July 6, 2011

Re: 121-129 York Street, Harborview Townhouses  
Final Site Plan Application  
Request for Reconsideration

We have requested that our Site Plan, and its conditions, be reconsidered at the July 12<sup>th</sup> Planning Board Hearing. In particular, we request that the Planning Board reconsider its vote to waive condition ii as a condition of approval (referenced on page 15 of "Planning Board Report" dated June 24, 2001 and prepared by Jean Fraser).

TITLE:
EXHIBIT A.
DIMENSIONED PARKING PLAN
(NOT FOR CONSTRUCTION)

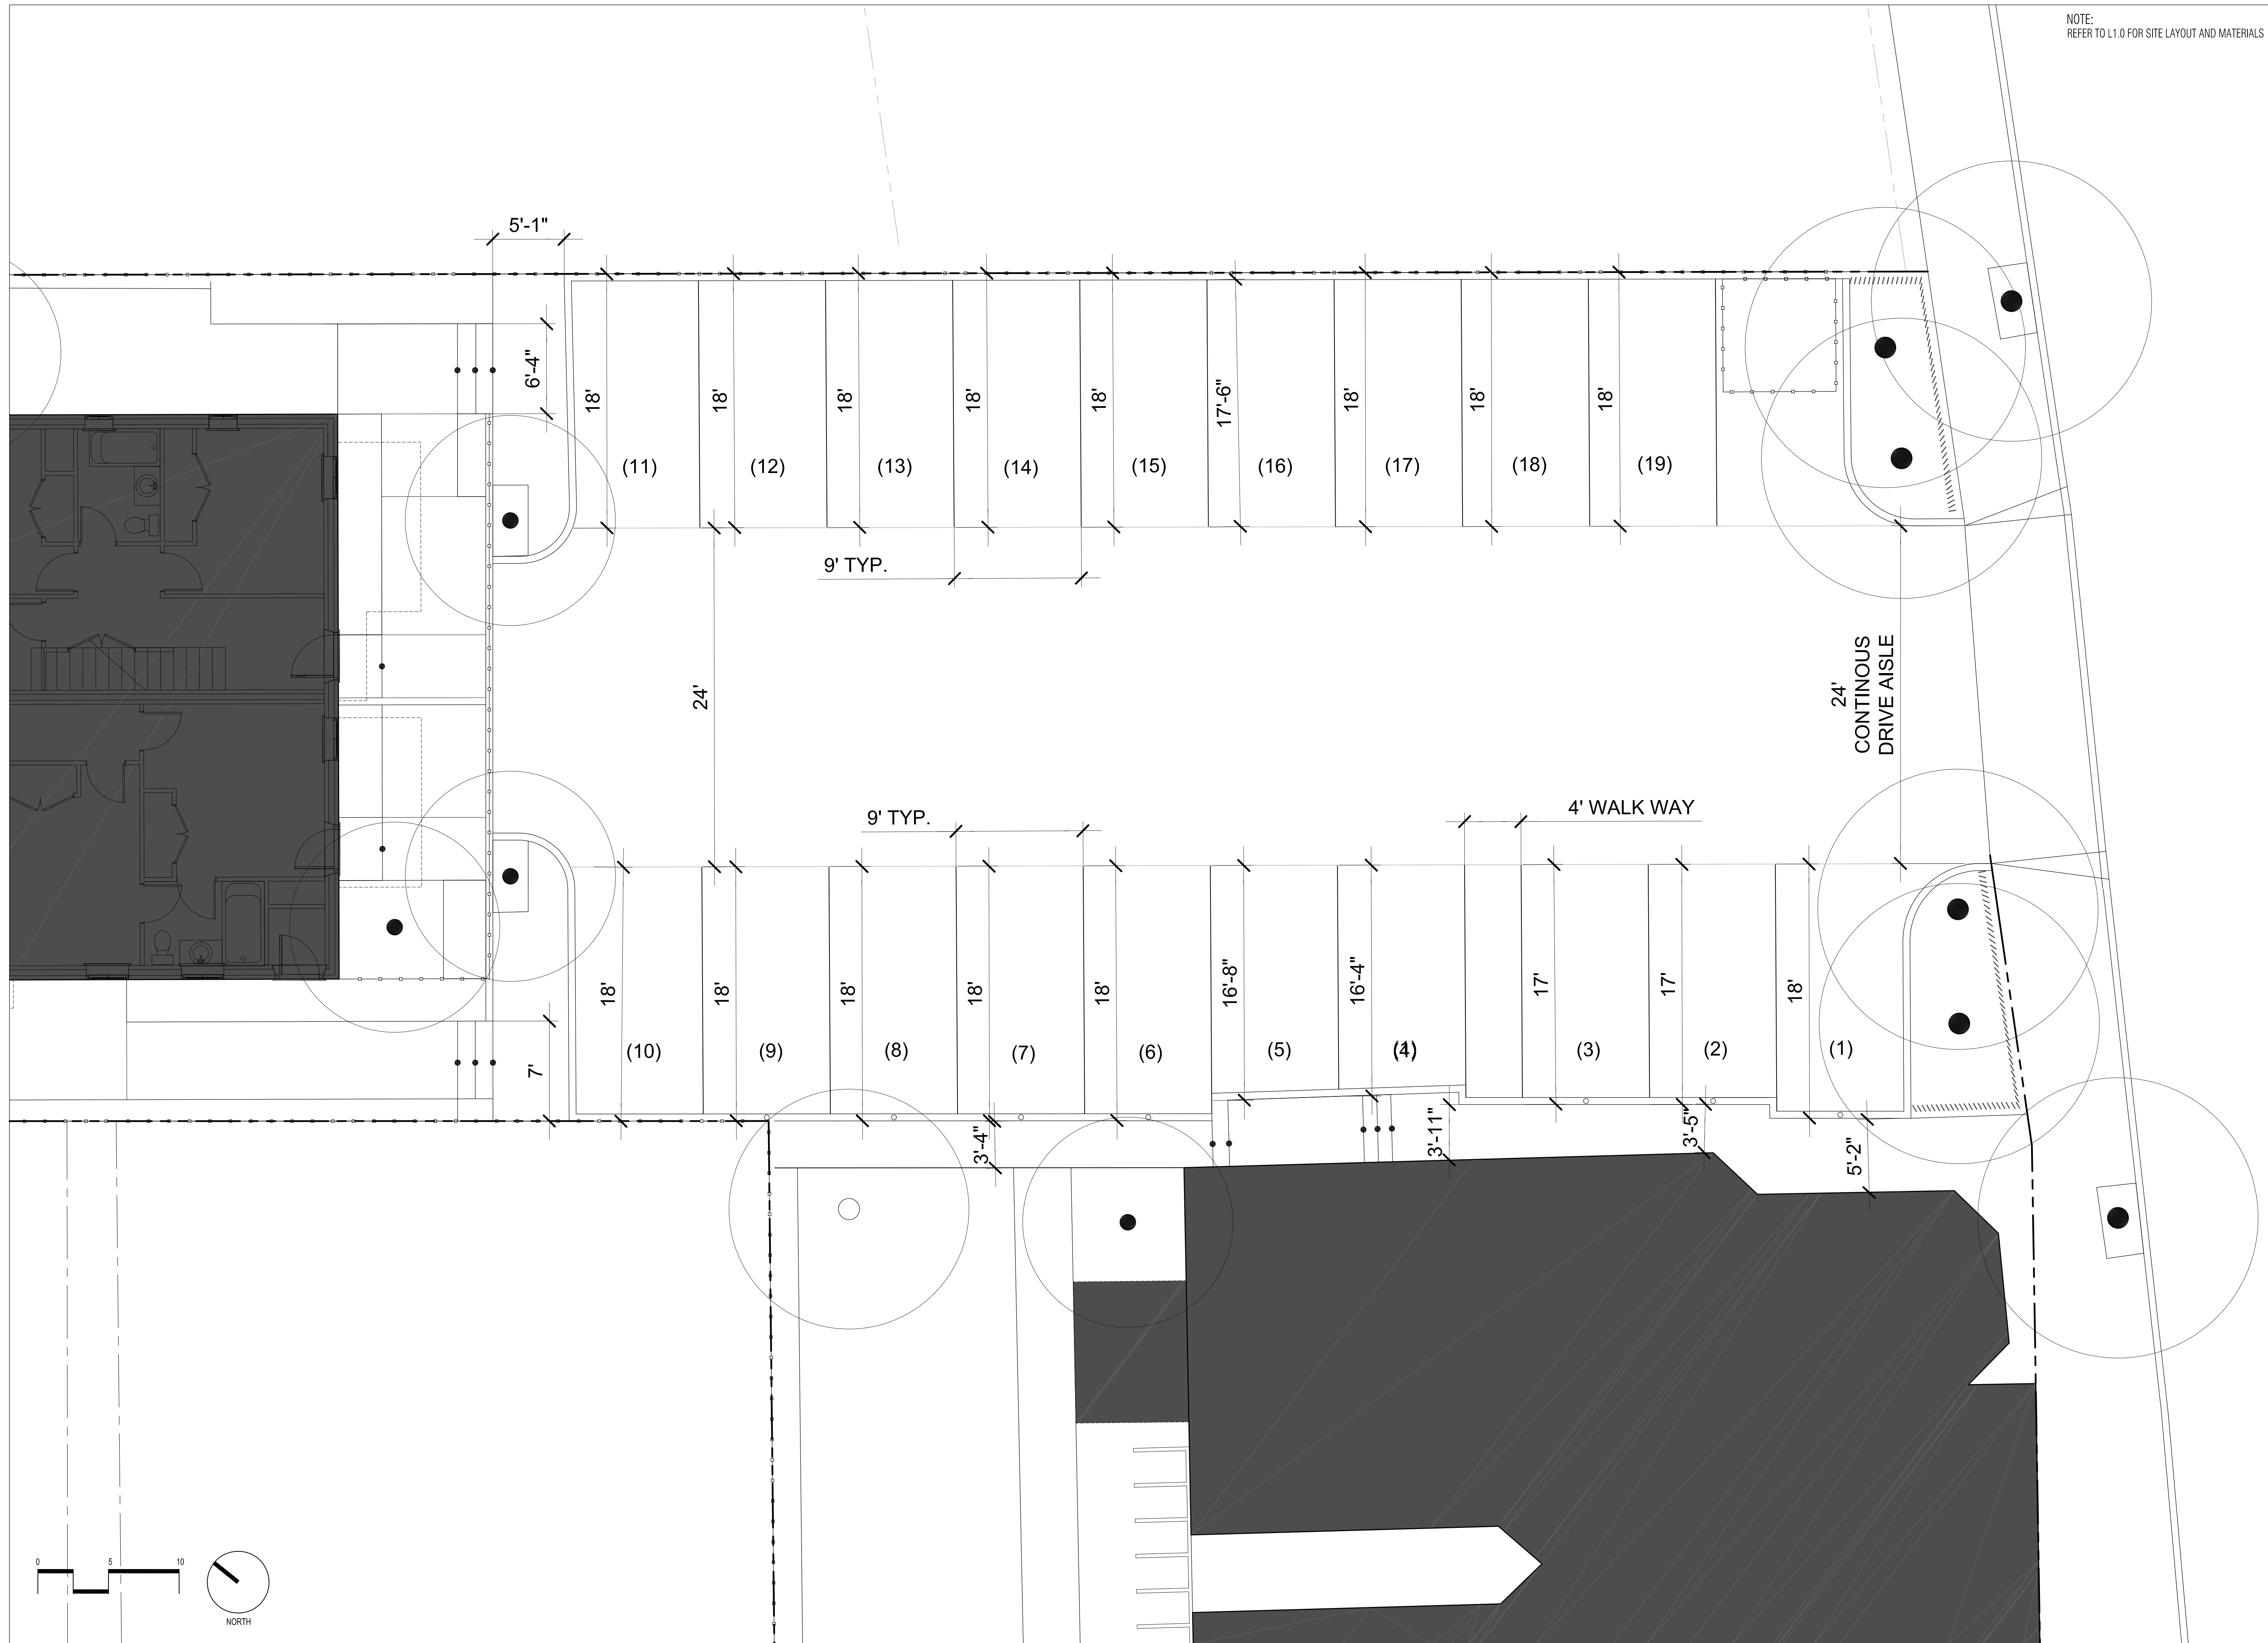
Additionally, we are seeking a waiver for one substandard parking space, above that which is allowed. Exhibit A to this letters shows that of 19 parking spaces, 15 are standard size (9' x 18'), while 4 are only slightly substandard. The substandard spaces are: 2 spaces at 9' x 17' (spaces #2 and #3), 1 space at 9' x 16'8" (space #5) and 1 space at 16'4" (space #4). A compact space is considered 8' x 15', so these substandard spaces are significantly larger than the minimum dimensions for compact parking. However,

We believe that our current plan meets the standard. Exhibit A shows a continuous internal walkway. While it is not a dedicated sidewalk, 14-526 (a)(2)(c)(iii) does not require “dedicated” access, nor does it refer to a “sidewalk”.

The walkway in Exhibit A starts on the sidewalk of York Street and extends roughly 35 feet west toward the new building. Along this stretch, steel bollards will be installed to prevent cars from overhanging the walkway. Next, the walkway, protected by curbing turns right and heads toward the drive aisle. At the center of the drive aisle, the walkway is 6’ wide and turns west and continues all the way to the proposed building. While in the drive aisle, the pedestrian walkway is differentiated by permanent stamped paving.

We request that you (1) affirm the previous approval of our Site Plan; (2) waive the aforementioned Condition ii., and (3) grant a waiver for allowing 21% of parking spaces to be substandard. Favorable rulings on these three items would allow the Harborview Townhomes project to go forward.
